Development Facilitation Team (DFT) – Review Comments

DRB Project No: PR-2020-004448 Date: 01/24/2023 Agenda Item: NA Zone Atlas Page: Q-16

Location: 5201 Hawking Dr. SE

Application For: SI-2023-00132 – Site Plan DFT (DFT)

UTILITY PLAN - WATER AND FIRE LINES

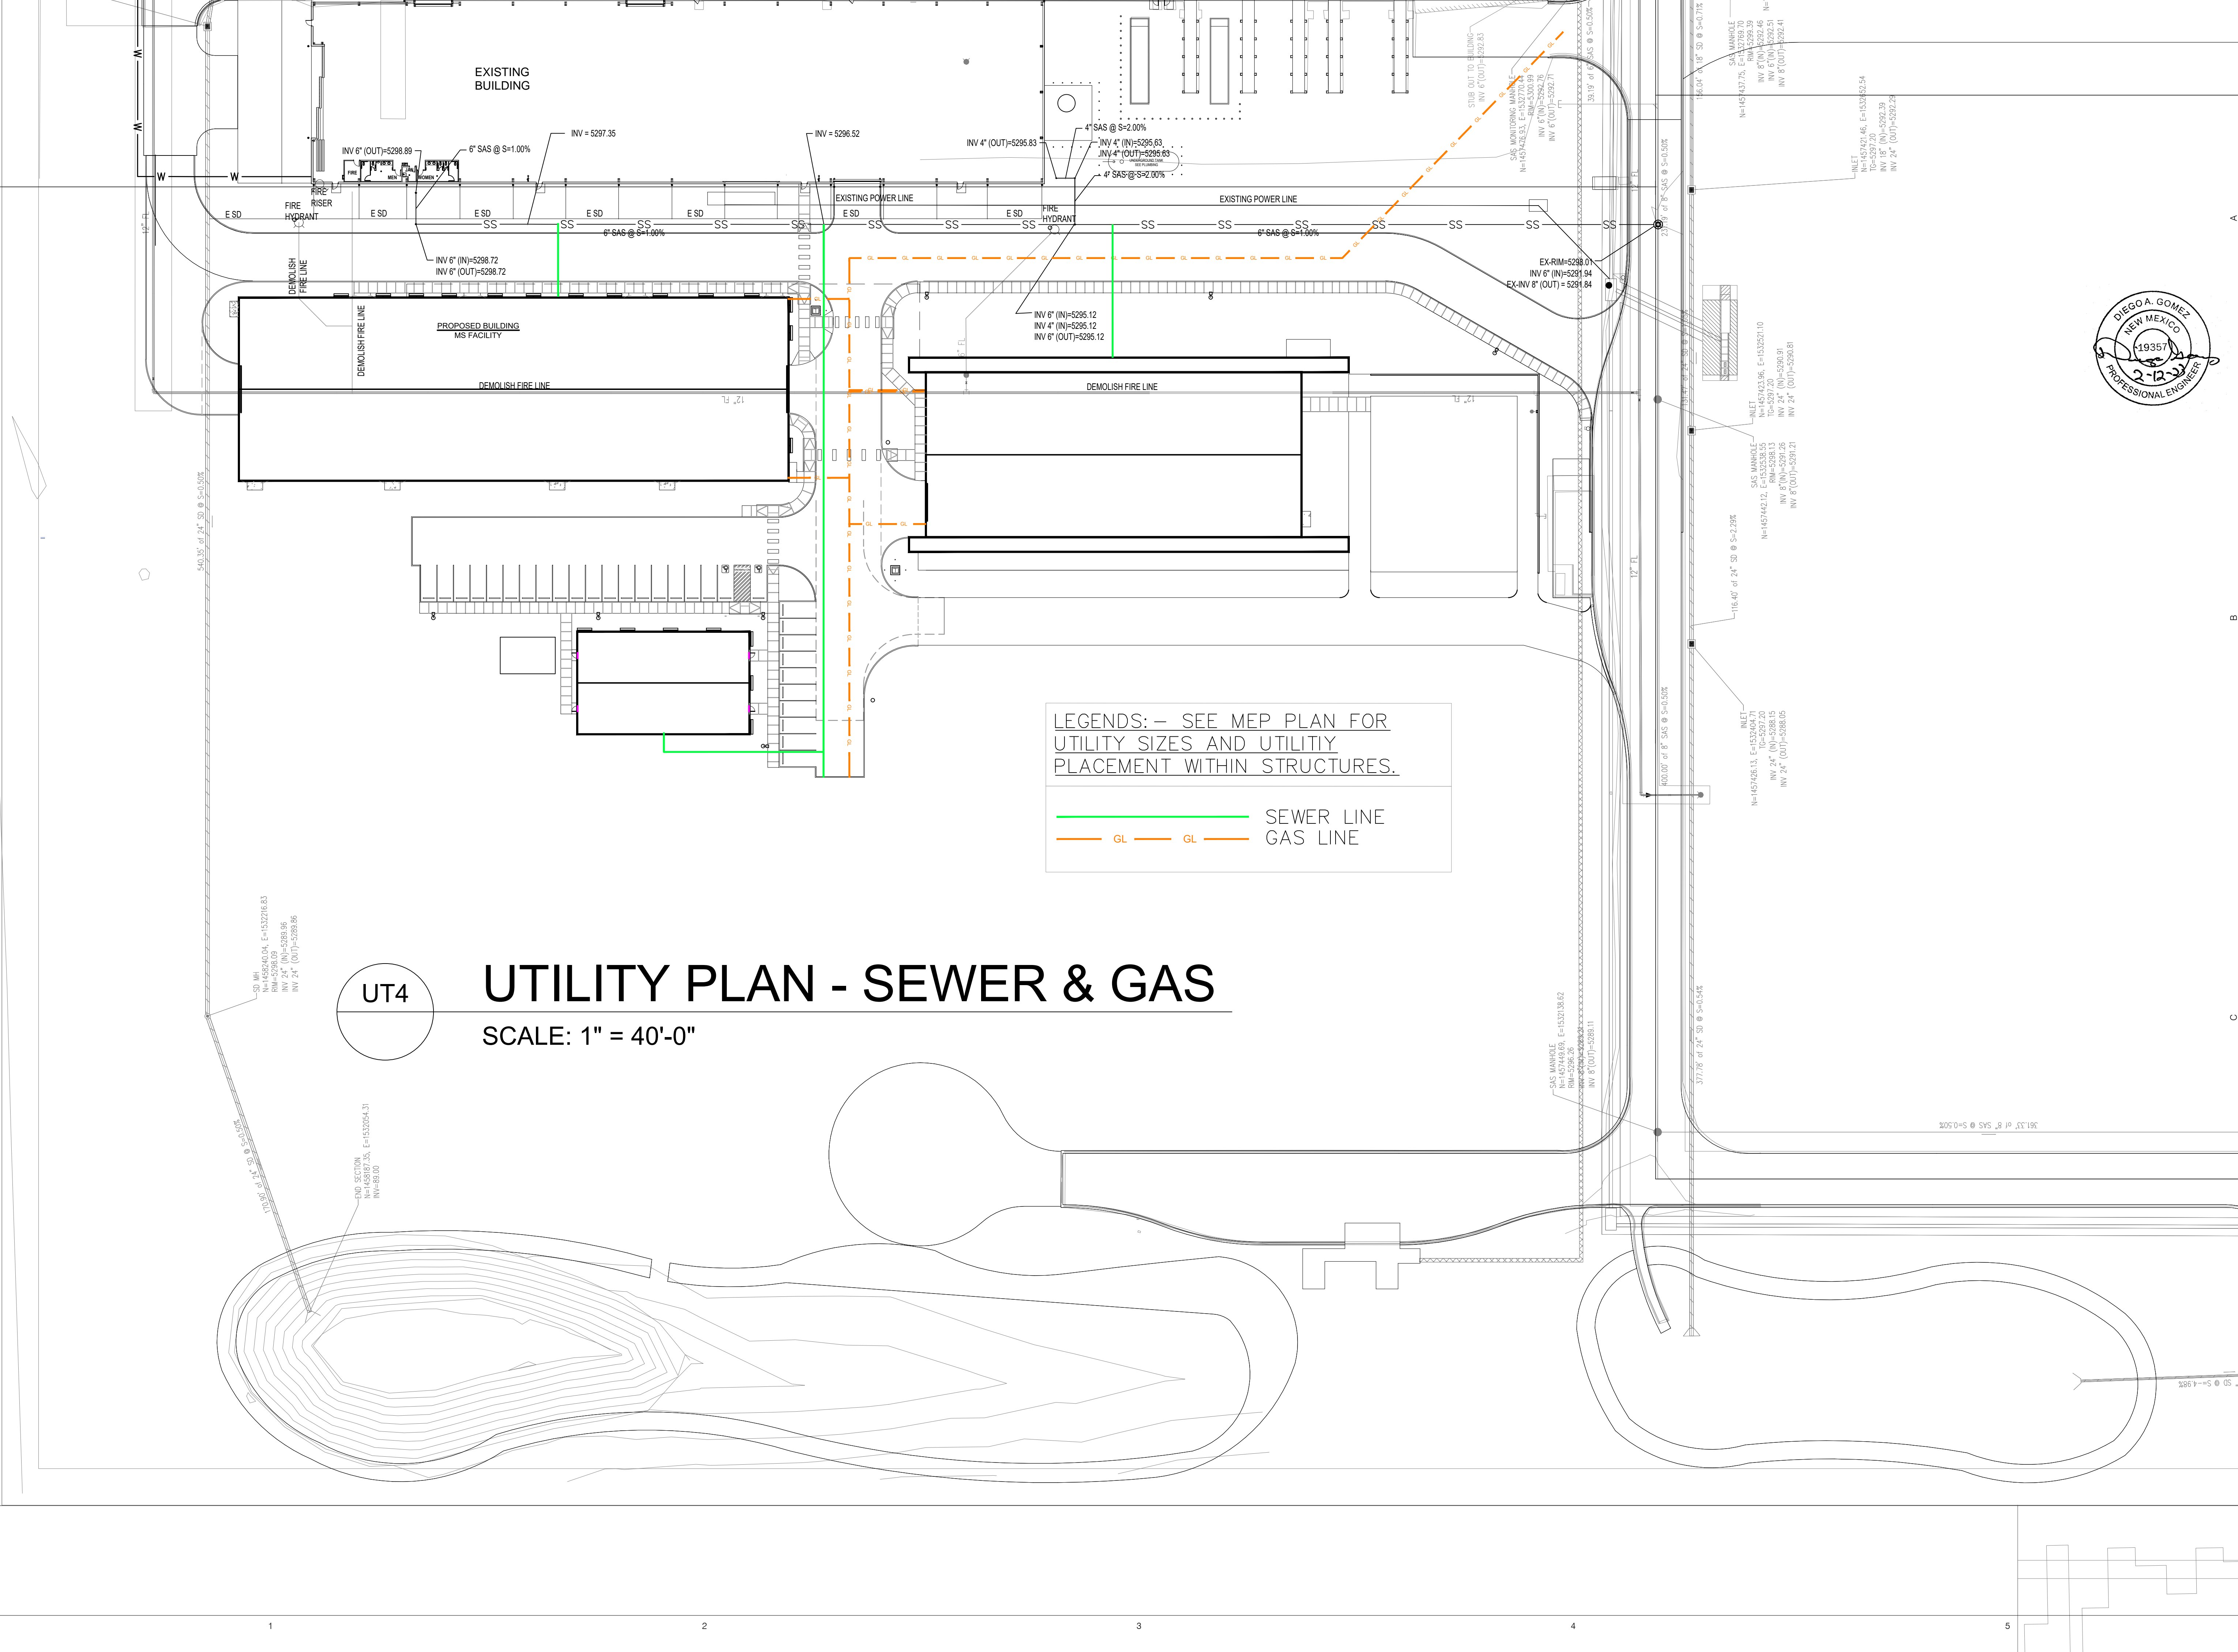
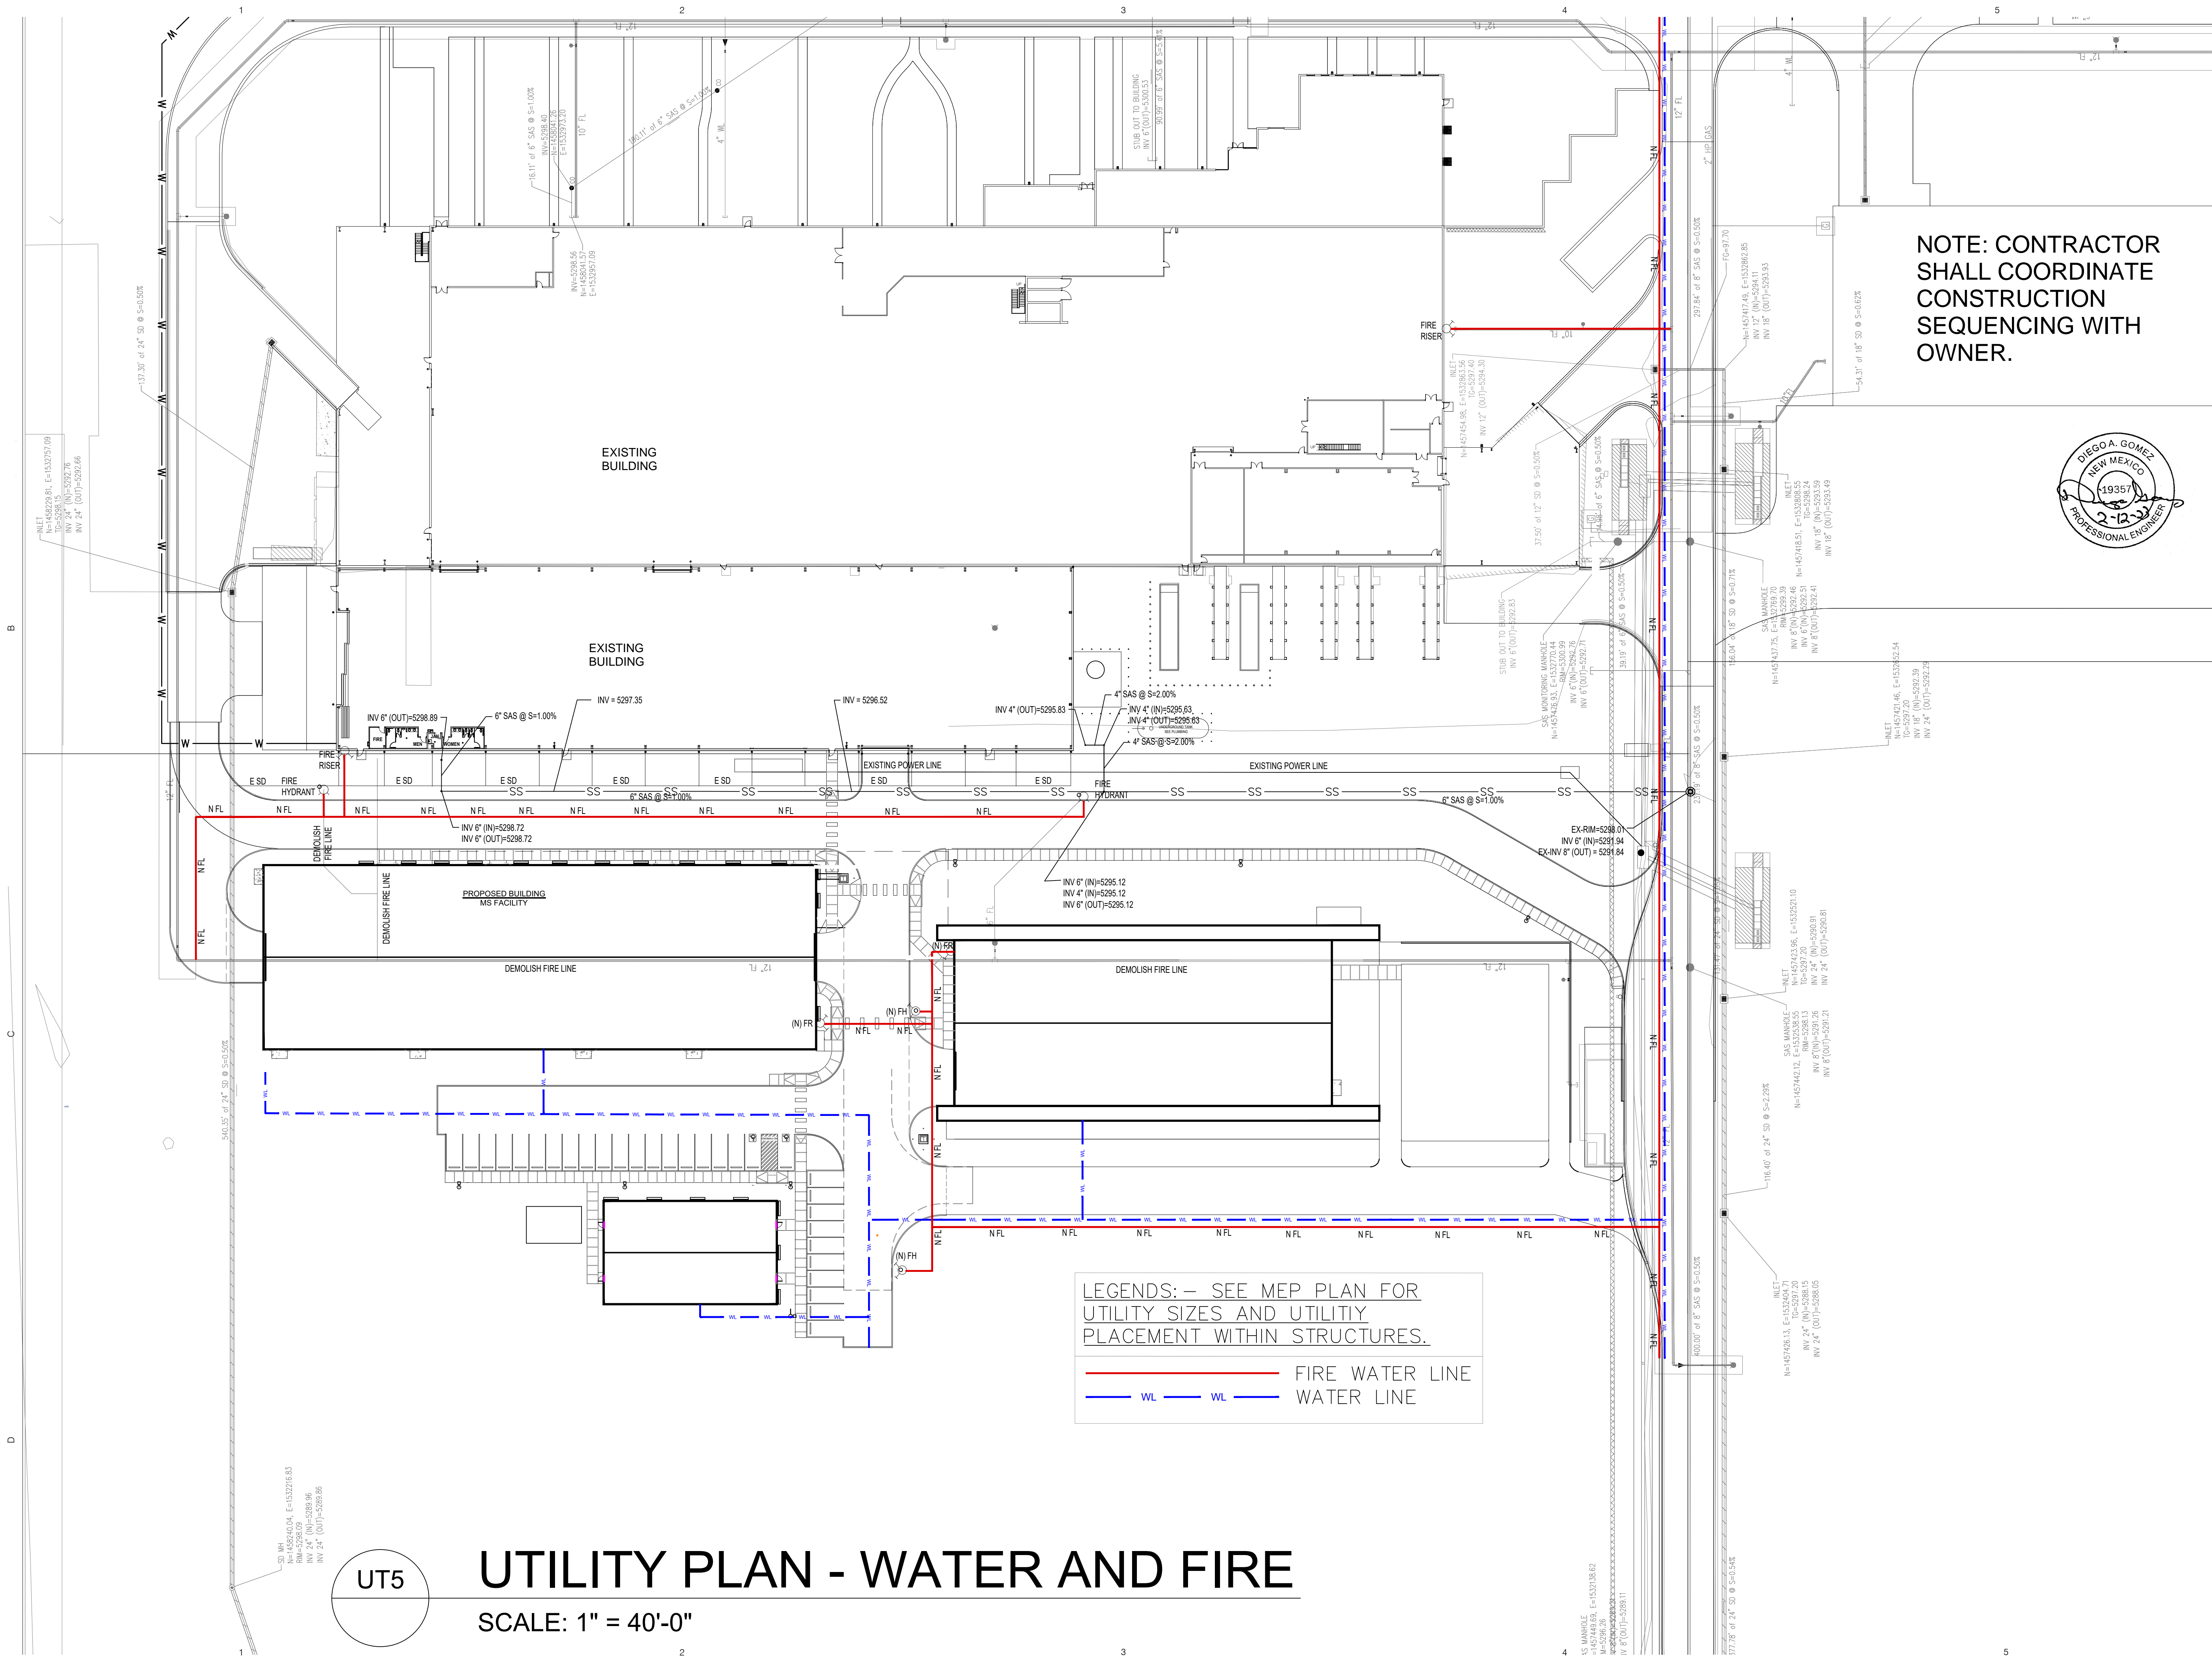
3. Ensure a note is placed on the utility plan stating that the site shall disconnect from the shared service upon completion of the work order and prior to CO given from the City of Albuquerque.

- a. Clearly show the disconnect on the utility plan.
4. Please show the newly proposed services along Hawking along with the new public infrastructure along Crick and Hawking on the overall Utility plan. Clearly define the sizes of all infrastructure and label each item as public or private.

5. Please add the following notes to the utility plan:
 - a. Coordination with Water Authority Cross Connection Section will be required to ensure proper backflow containment is in place prior to release of meter for the site. Contact the Cross Connection Section at 505-289-3454.

- b. Coordination with the Water Authority Pre-Treatment Engineer is required to ensure the site complies with Water Authority Sewer Use Ordinance. Contact the Pre-Treatment Engineer at 505-289-3439.
